LSC Responses to TIS Redline Comments

Villages at Sterling Ranch Traffic Impact Study (LSC #S224580) April 12, 2024 PUDSP226 ¹

RE: Villages at Sterling Ranch
Traffic Impact Study
El Paso County, Colorado
LSC #S224580

Figure 1  
SITE LOCATION

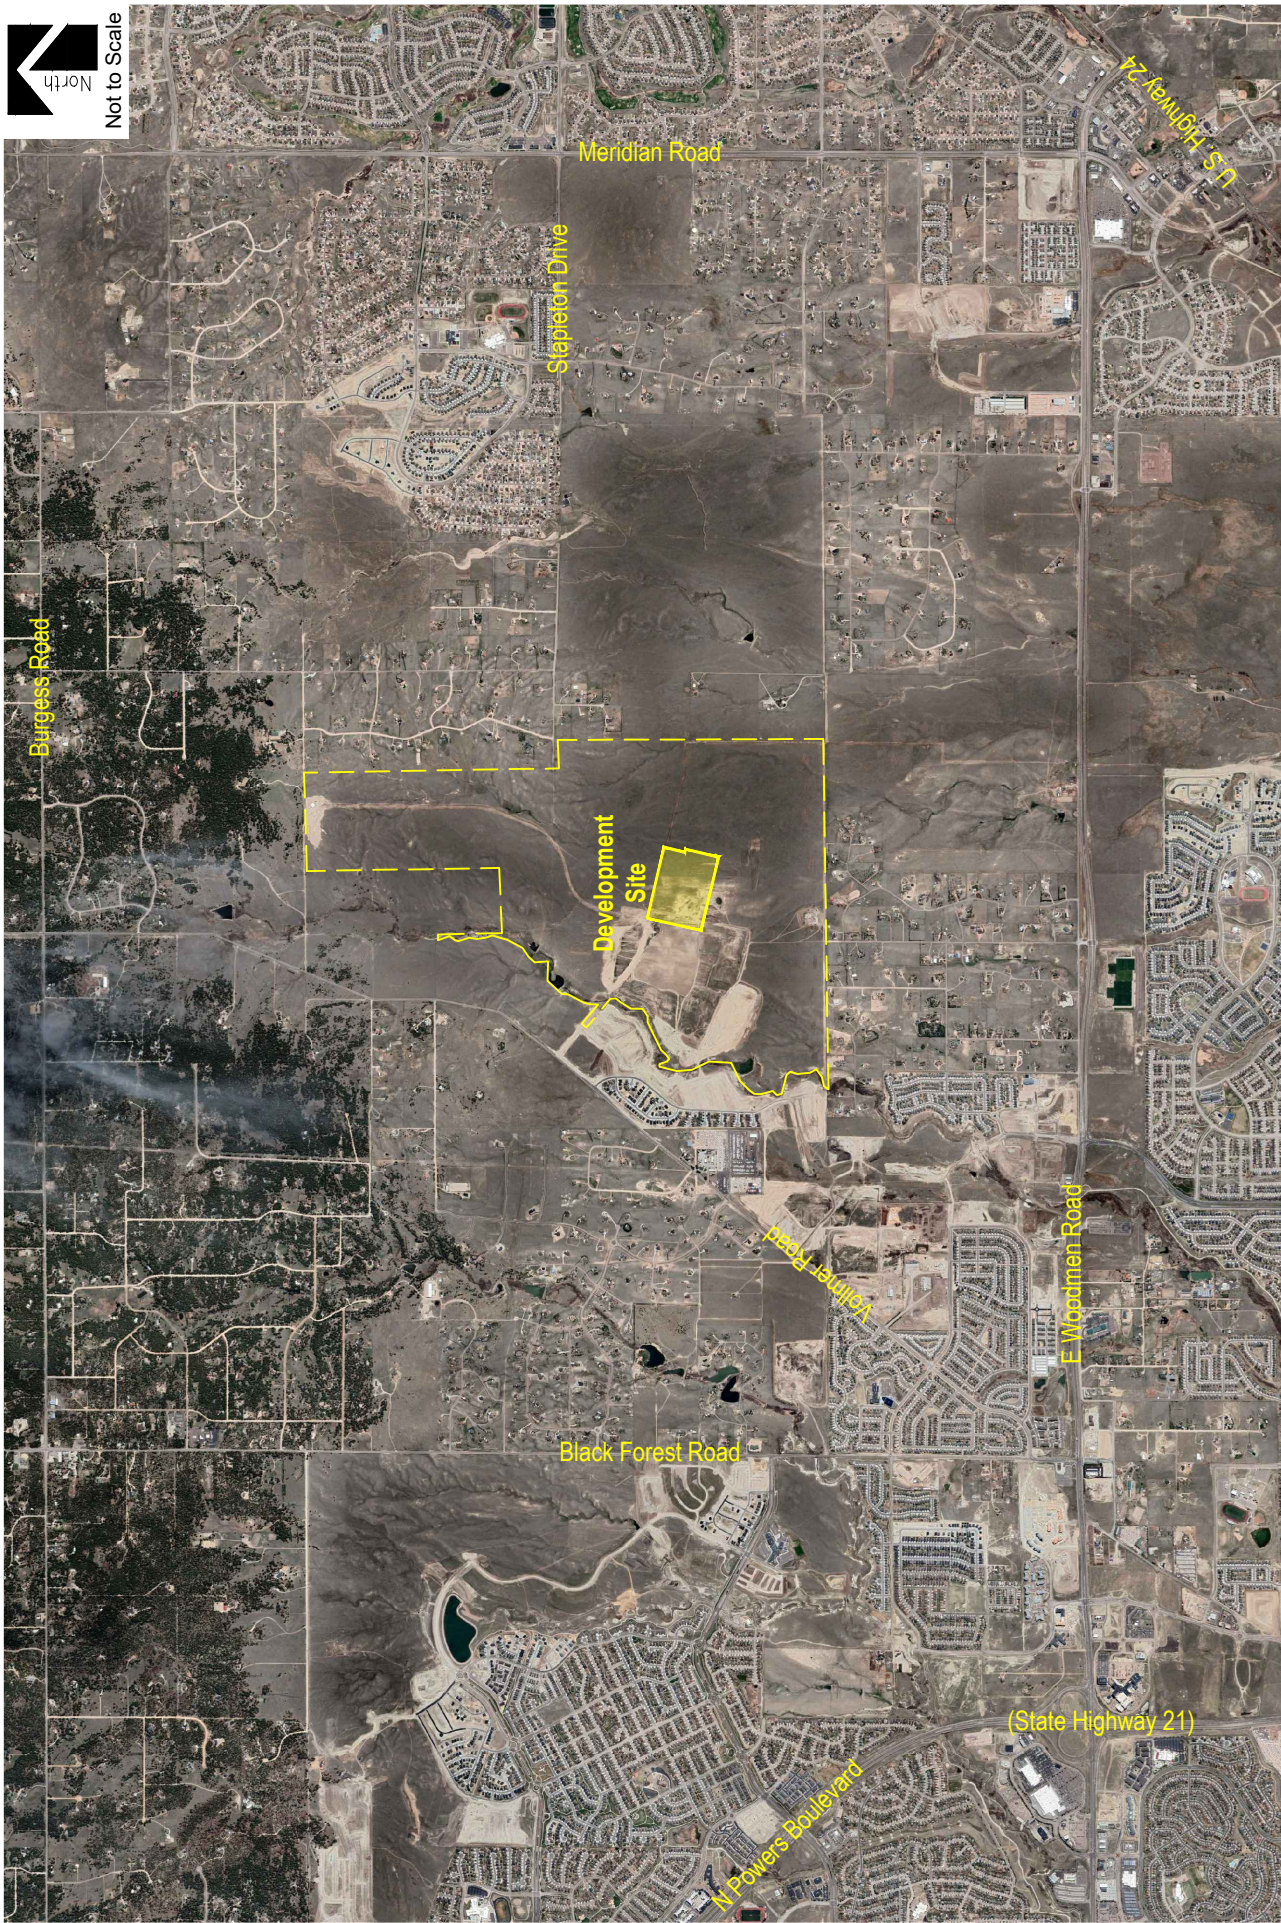
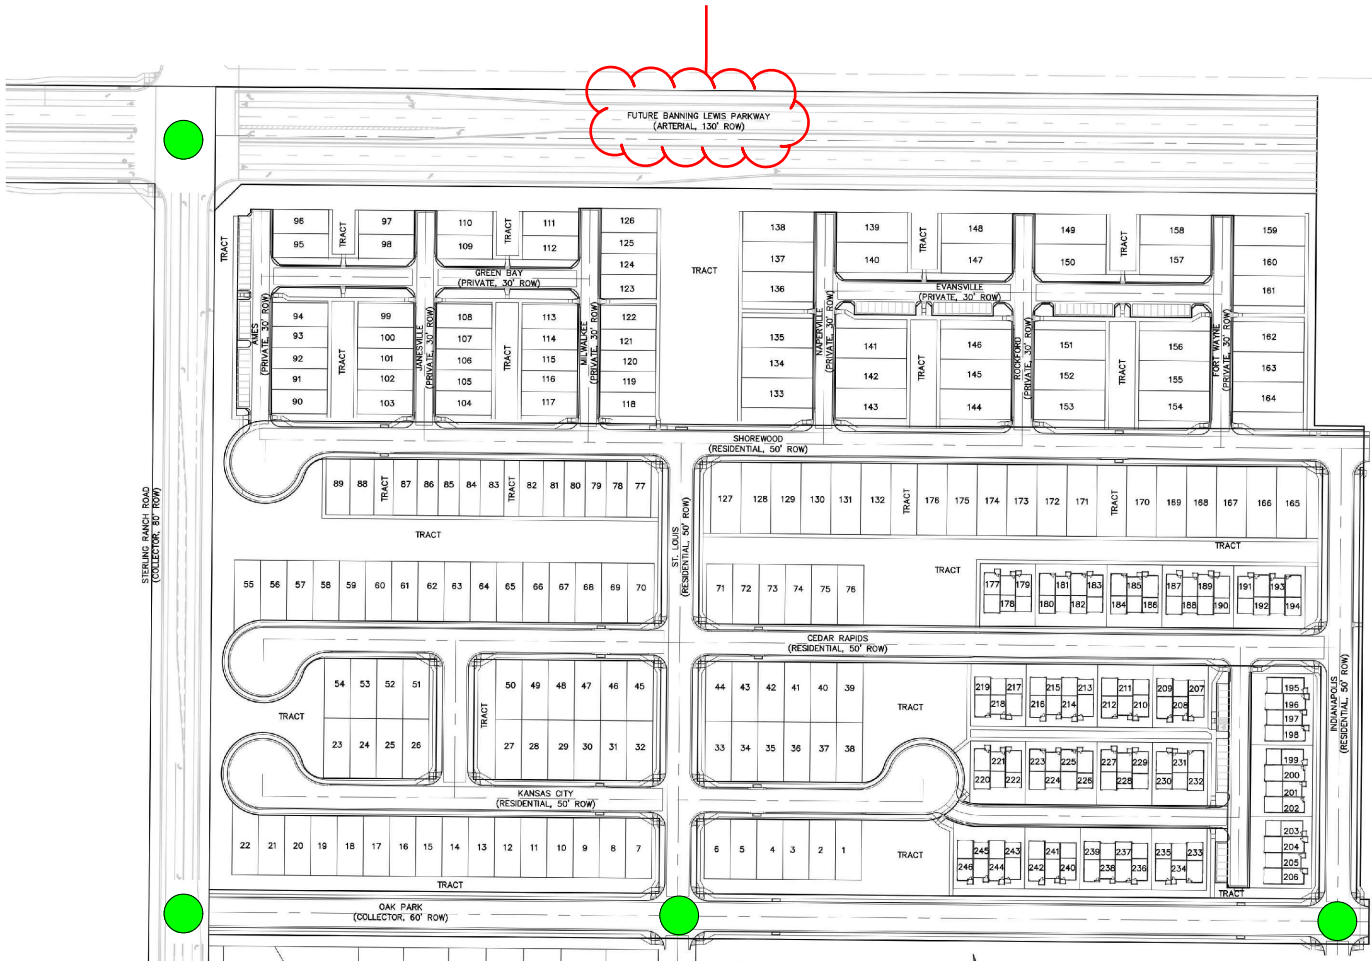
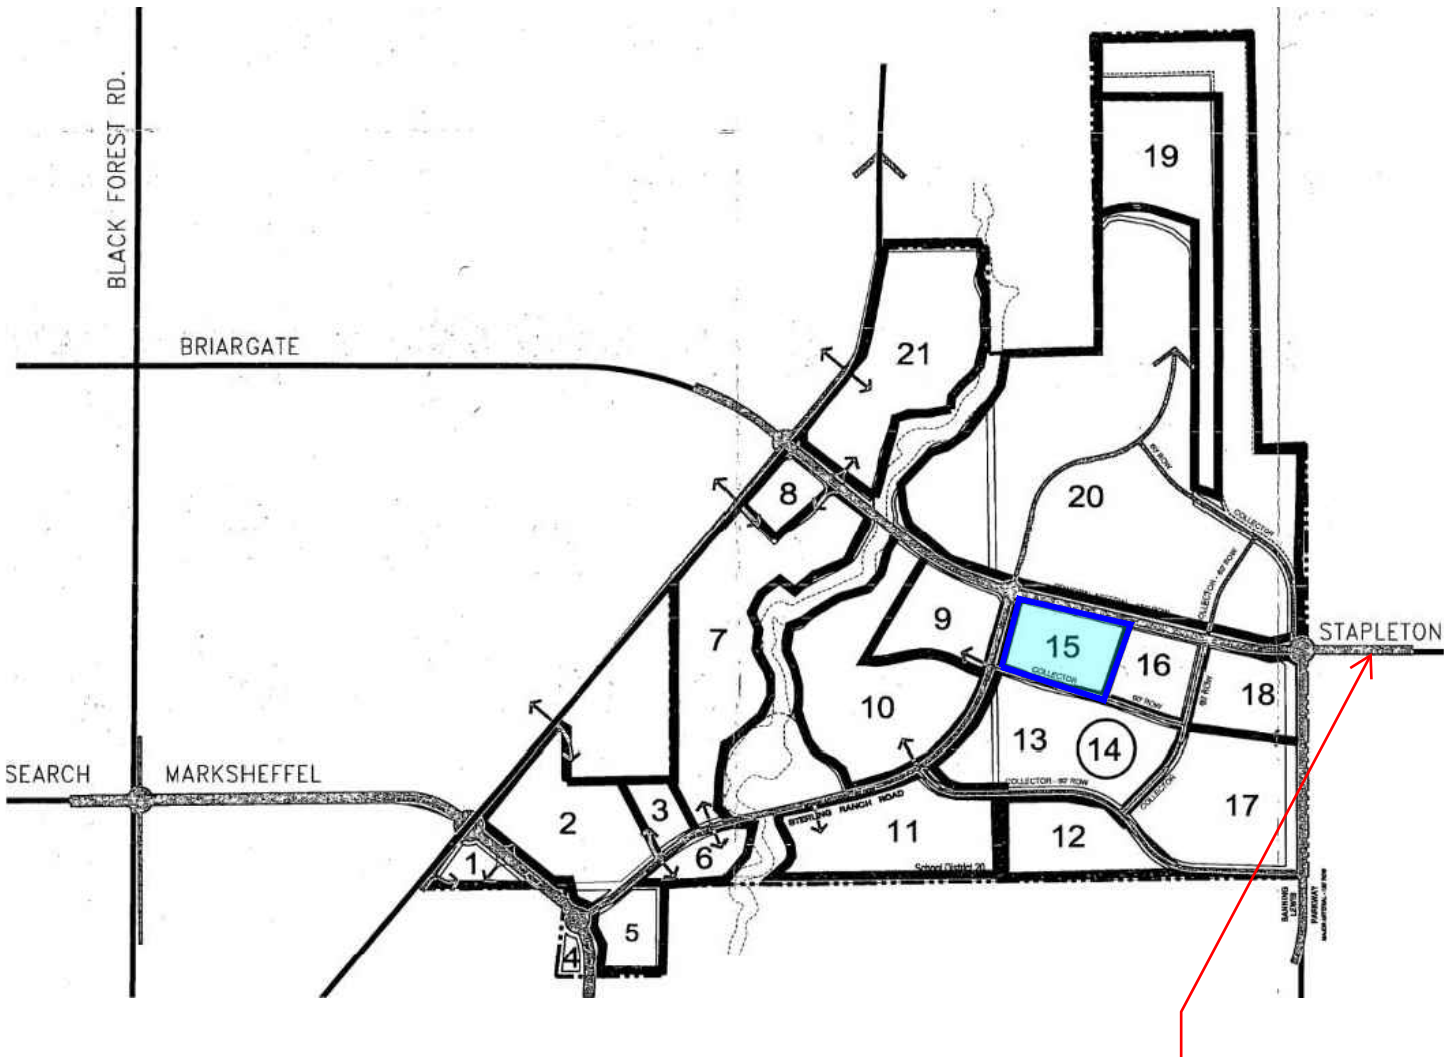
[Use Briargate Parkway](#) ¹

[Use Briargate Parkway](#)

Author: Kirstin Ferrin Subject: Sticky Note Date: 8/22/2024 12:40:50 PM
LSC Response: Revised as requested.
